From: Michael Pickup [REDACTED]
Sent: 04 July 2012 10:07
To: Susan Leeson
Subject: RE: Planning application no. EG/35/12 - FAO Mrs S Leeson
Attachments: TCPS 479A Amended Site Location Plan Drawing 04.07.12.pdf

"Retention of horsebox hire business, mobile home, office/staff room, workshop/storage building and an area of hardstanding".

Drawing No. TCPS 479A/1 Rev B

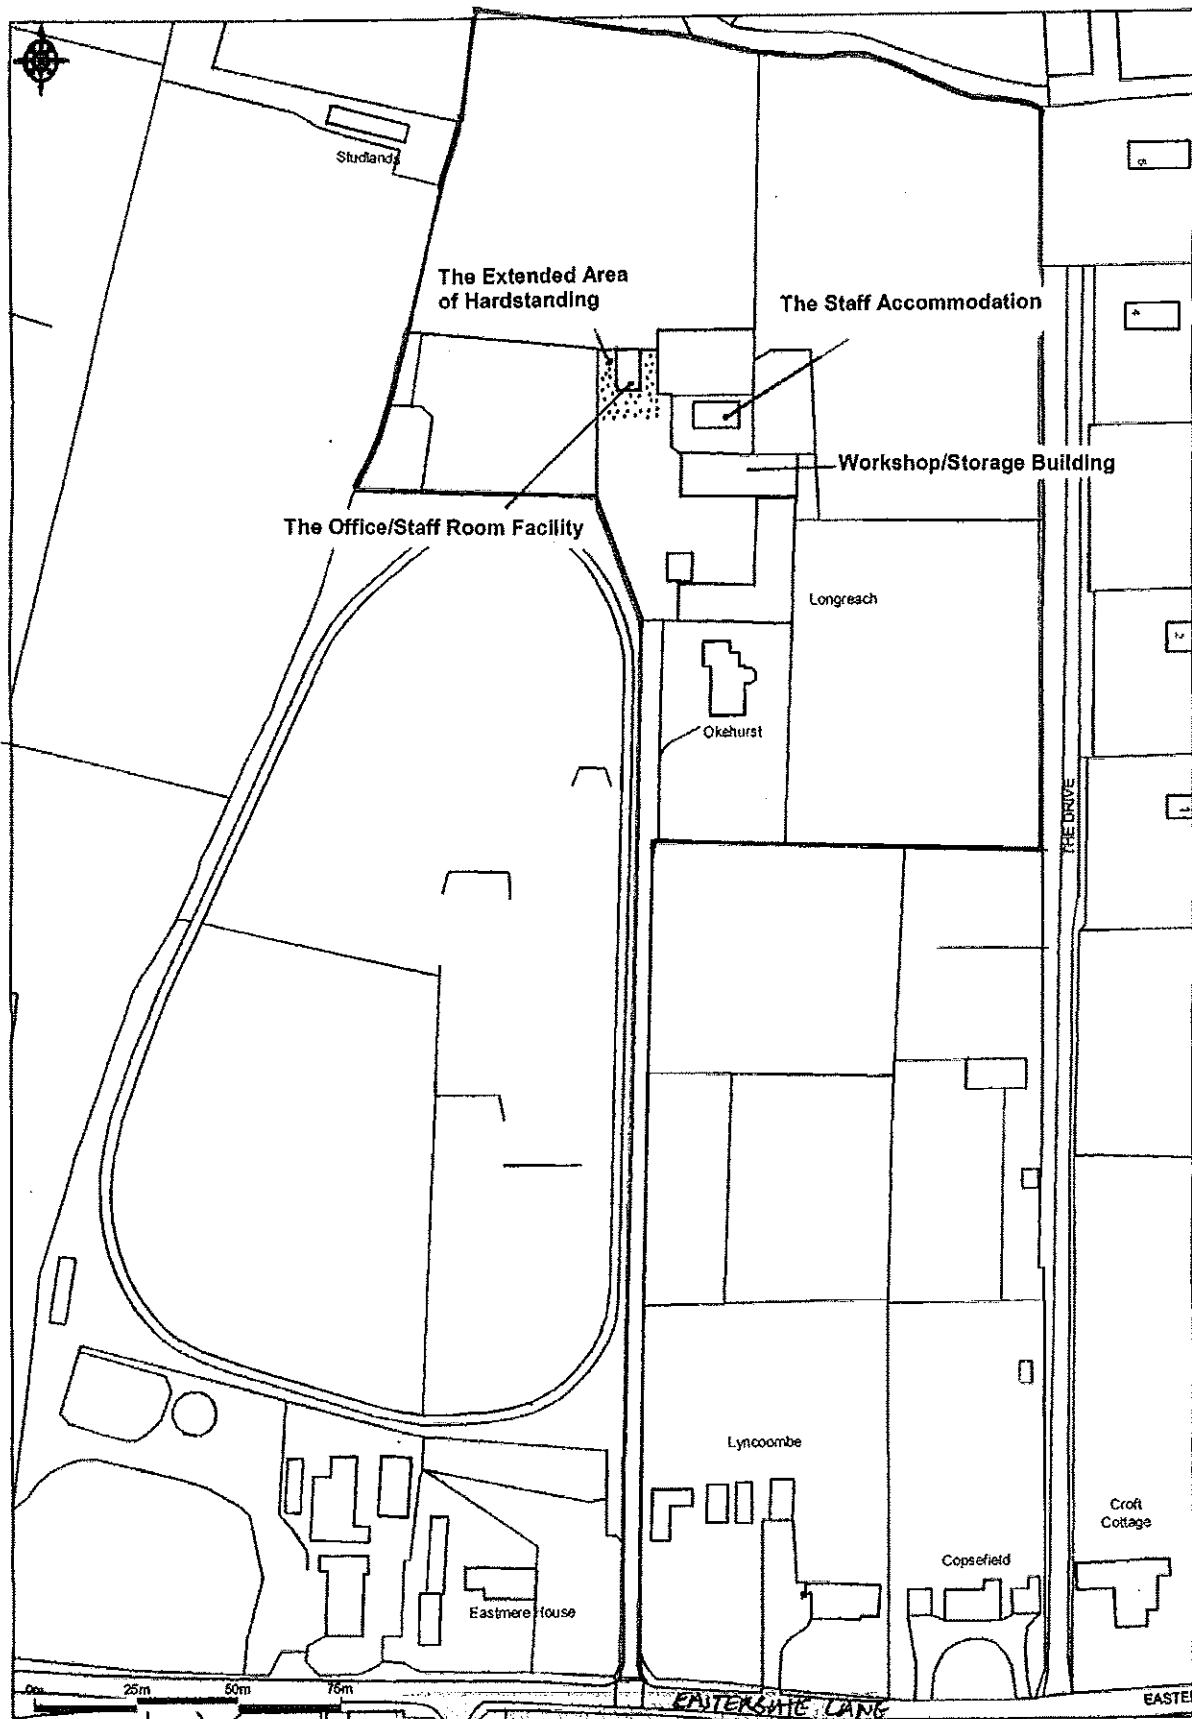
Thank you, please can you also send a revised site, block plan to include the barn.

The amended drawing (no. TCPS 479A/1 Rev B) is attached. I have also deleted two buildings in the central courtyard area as these no longer exist.
